Riverside Energy Park

Applicant's response to Bexley Natural Environment Forum's Deadline 8 Submission

8.02.94

October 2019

Terrestrial Invertebrate Survey Areas 2018

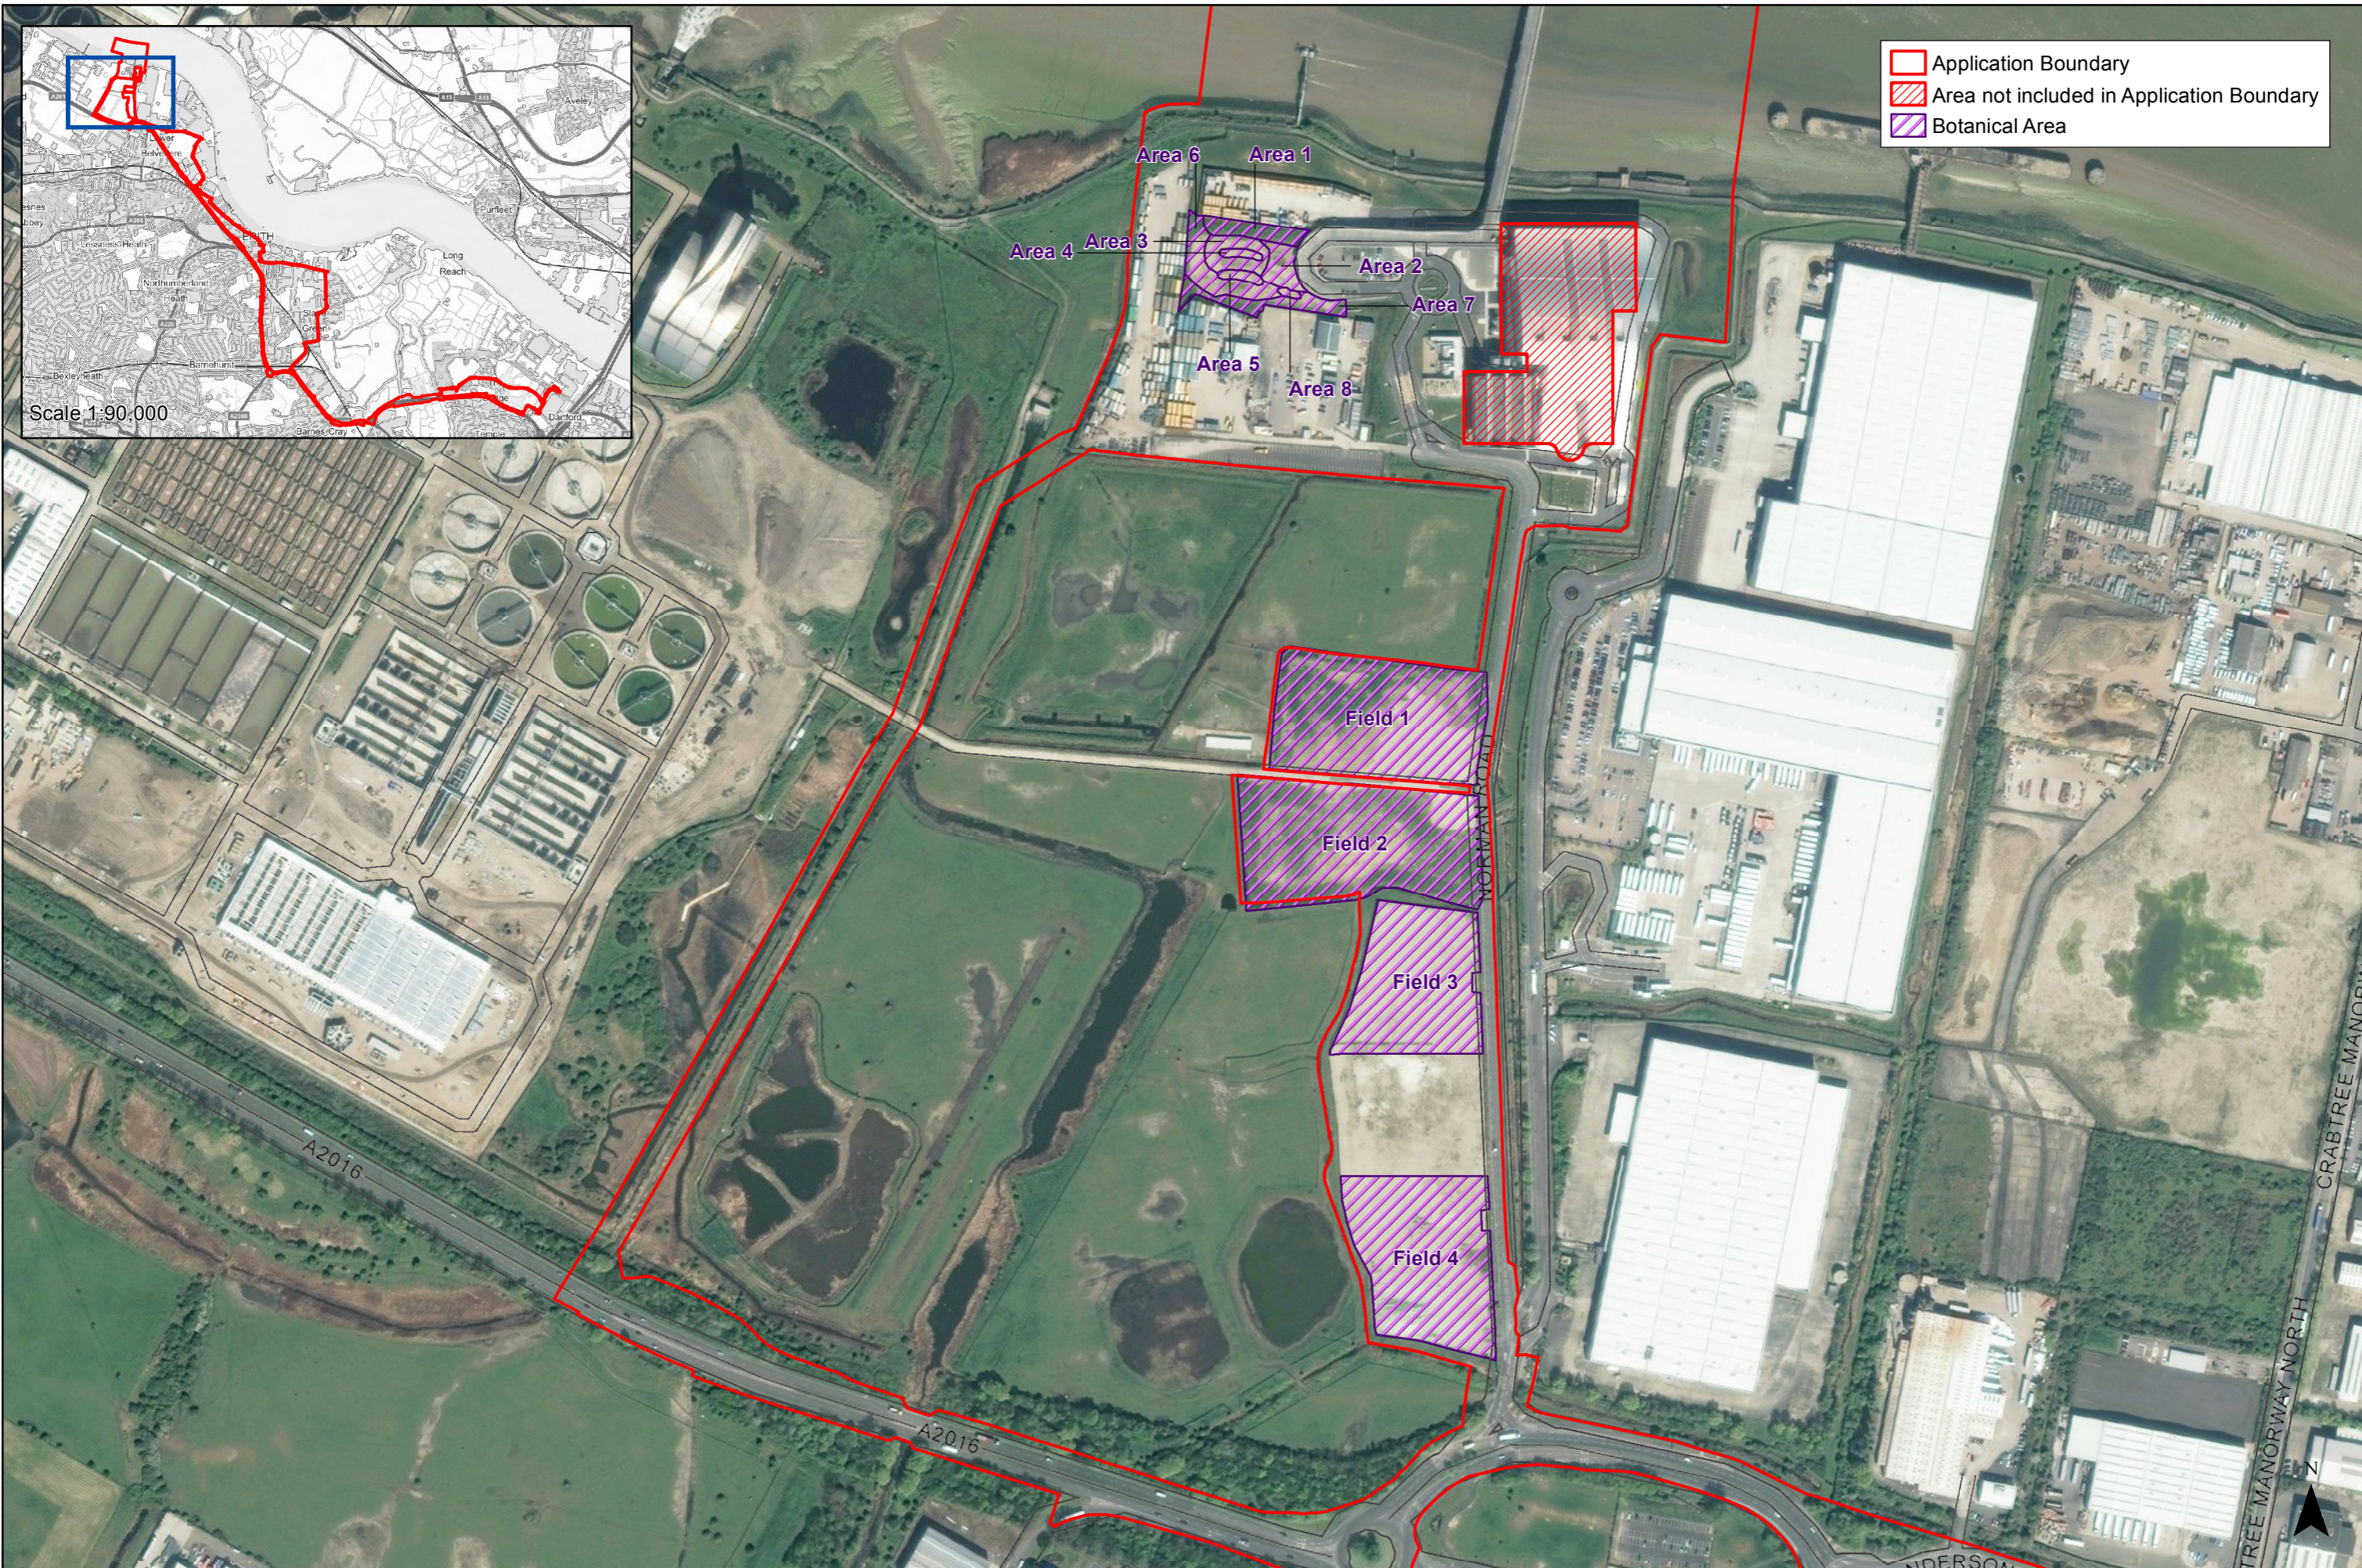
1.2.15 BNEF also queries the timing of baseline survey, subsequent evaluation of ecological features, and resultant impact assessment relating to the invertebrates, specifically shrill carder bee, and breeding birds, specifically skylark, within the Data Centre site.

- 1.2.19 It should be noted that the 2018 invertebrate survey recorded shrill carder bee, referred to by BNEF, in Survey Areas 1-4 shown in **Figure 1** provided in the **Technical Appendix G.3 Terrestrial Invertebrate Survey Report 2018 (6.3, APP-082)**. The 2018 survey confirmed that the shrill carder bee is present on the Data Centre fields and other areas within the REP site. Mitigation for any potential impact on invertebrates is set out in **Table 1** of the **OBLMS (7.6, REP8-012)** and identifies that in addition to the off-site biodiversity enhancements delivered through the offset (meaning delivery of OMH suitable for use by invertebrates), the Applicant is committed to the recycling of existing upright sleepers and wooden seating units from the main REP site which will be moved to alternative locations within the REP site. These would be enhanced to provide nesting sites for cavity nesting bees and wasps by drilling assorted diameter (2-10 mm) holes in them. In addition, as an enhancement measure, two-three simple sandbanks created out of compressed fine grade sand or soil (not hardcore) would be installed at suitable locations within the REP site to create suitable nesting sites for bees and wasps. The Applicant also confirms that green roofs and bio-solar roofs will be considered at the detailed design phase.

- 1.2.16 As identified in **Chapter 11 Terrestrial Biodiversity** of the **ES (6.1, REP-023)** and its supporting Technical Appendices, the survey work for both invertebrates and breeding birds was carried out at appropriate times and in the appropriate season by experienced surveyors. The invertebrate surveys included surveys undertaken between April and September 2018 inclusive. The breeding bird surveys included 5 survey visits between April and June 2018 inclusive.
